CITY OF ALBUQUERQUE

October 8, 2018

Re: Maverik Store
SW Corner of Comanche Rd. and Princeton Dr.
Traffic Impact Study
Engineer's Stamp dated 9-17-18 (G16-D029)

LOS / Volume Analysis Maps

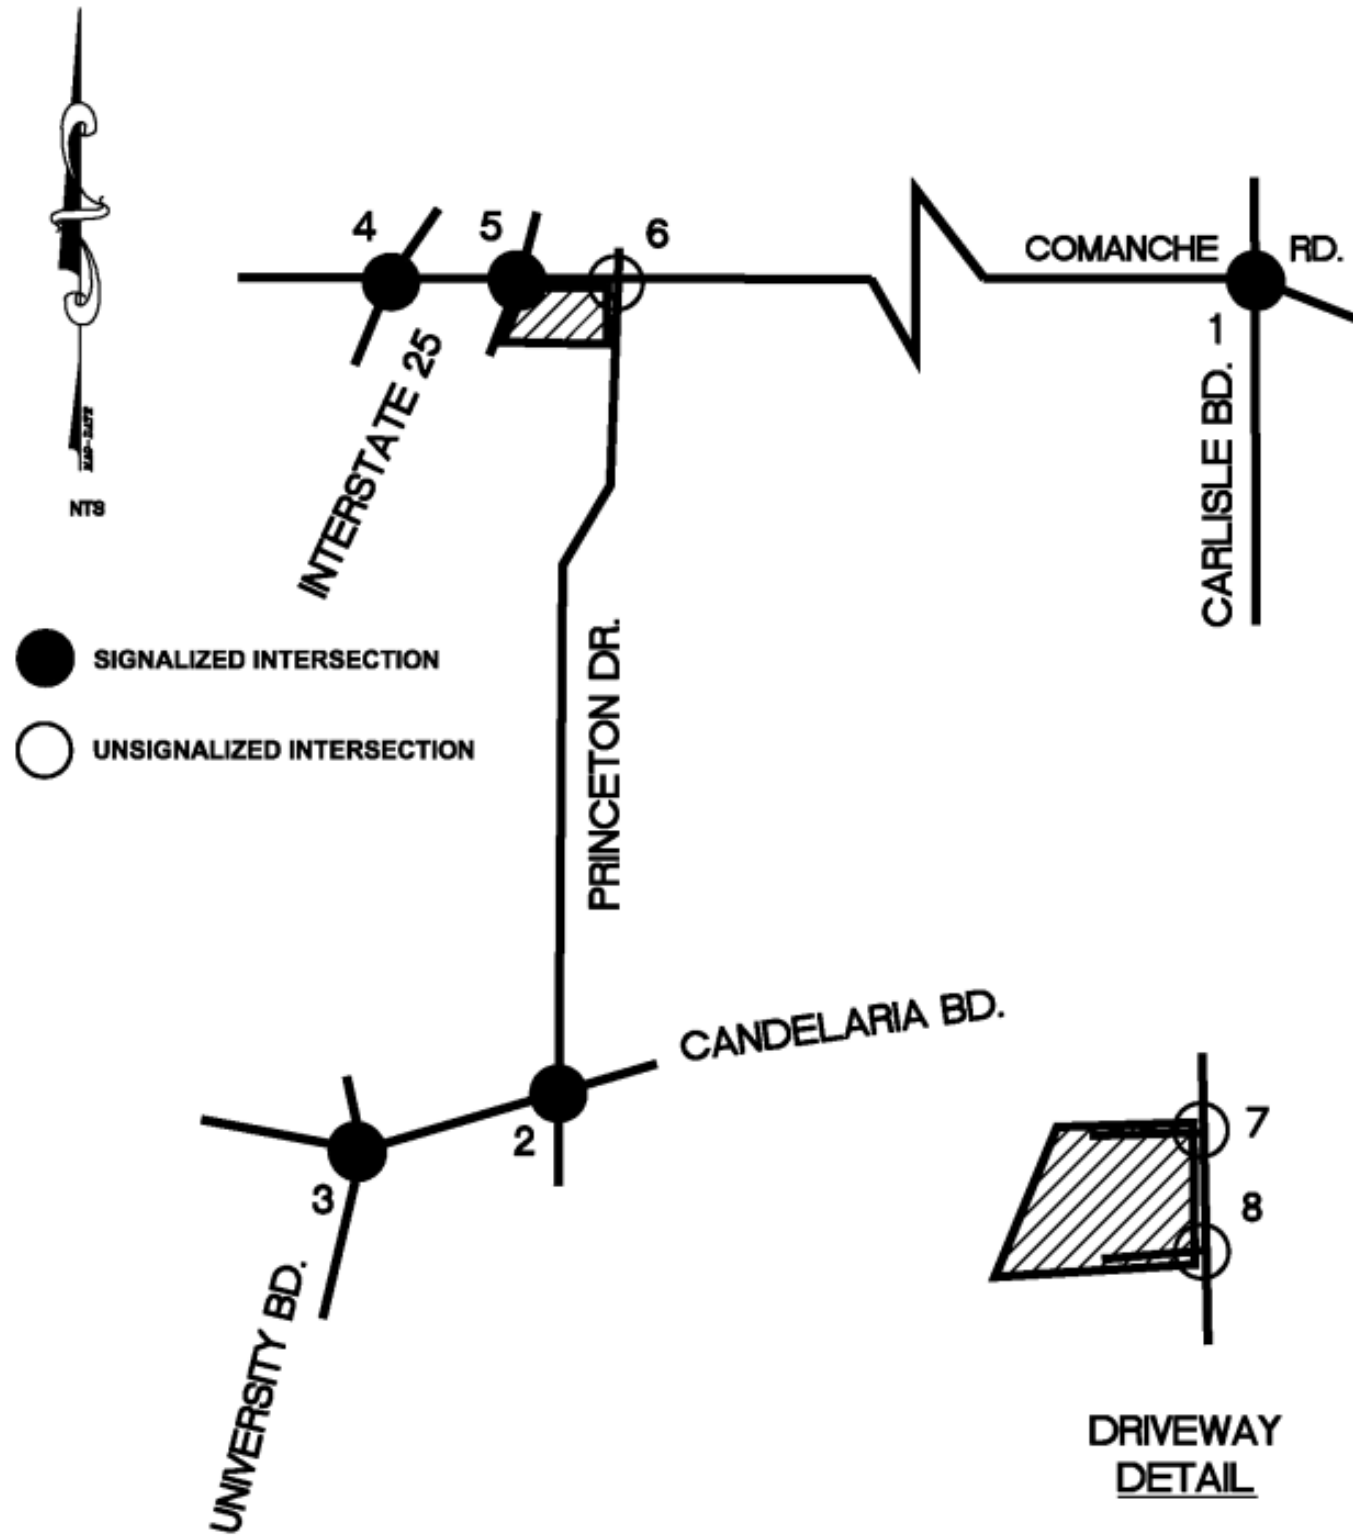
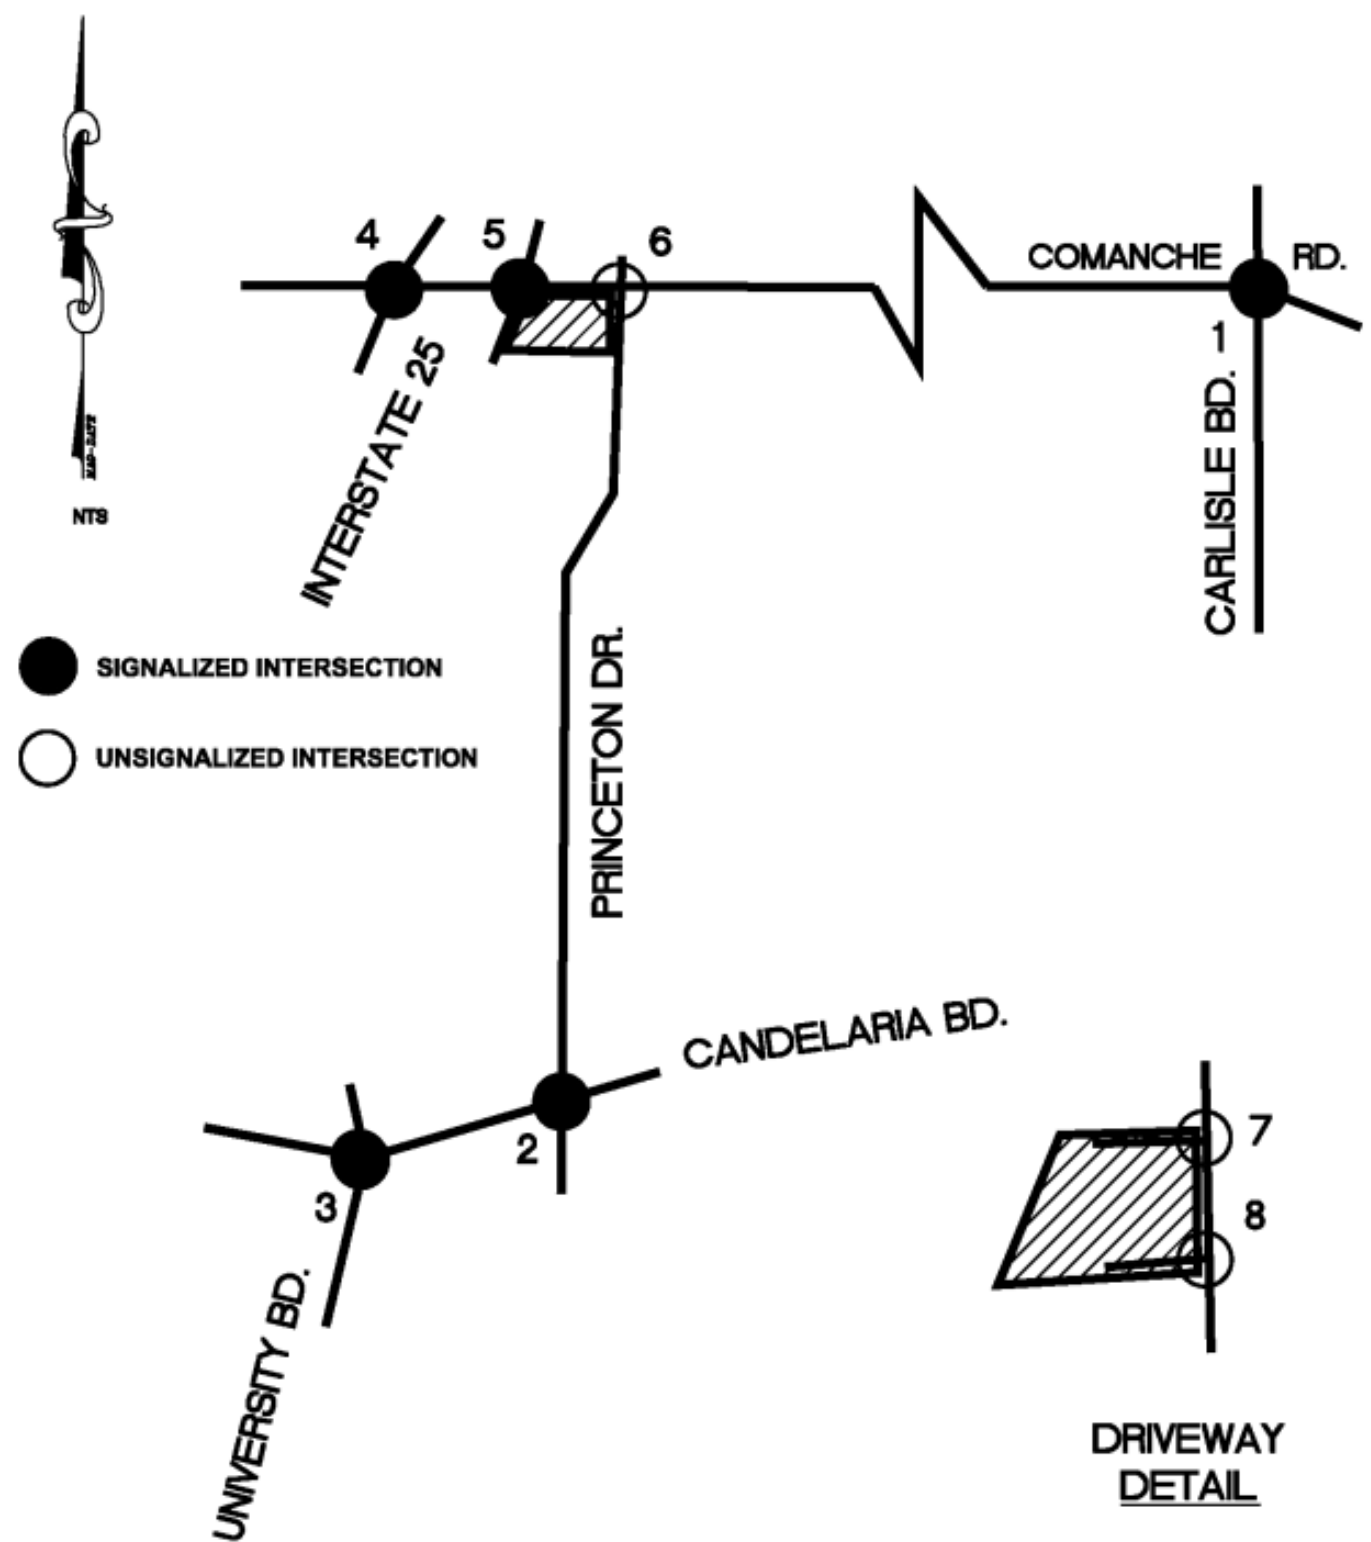
1. Page 9 – Last sentence of last paragraph shows trip distribution sheets are on pages A-9 thru A-16. These should be listed as A-12 thru A-20.
2. Pages 10 – Shows percentage trip assignment for commercial trips to be on pages A-15 thru A-16. These should be listed as A-18 thru A-20.
3. After Page 31 in the Appendix – There are two LOS Volume Analysis Maps that are not listed or numbered in the appendix table of contents.
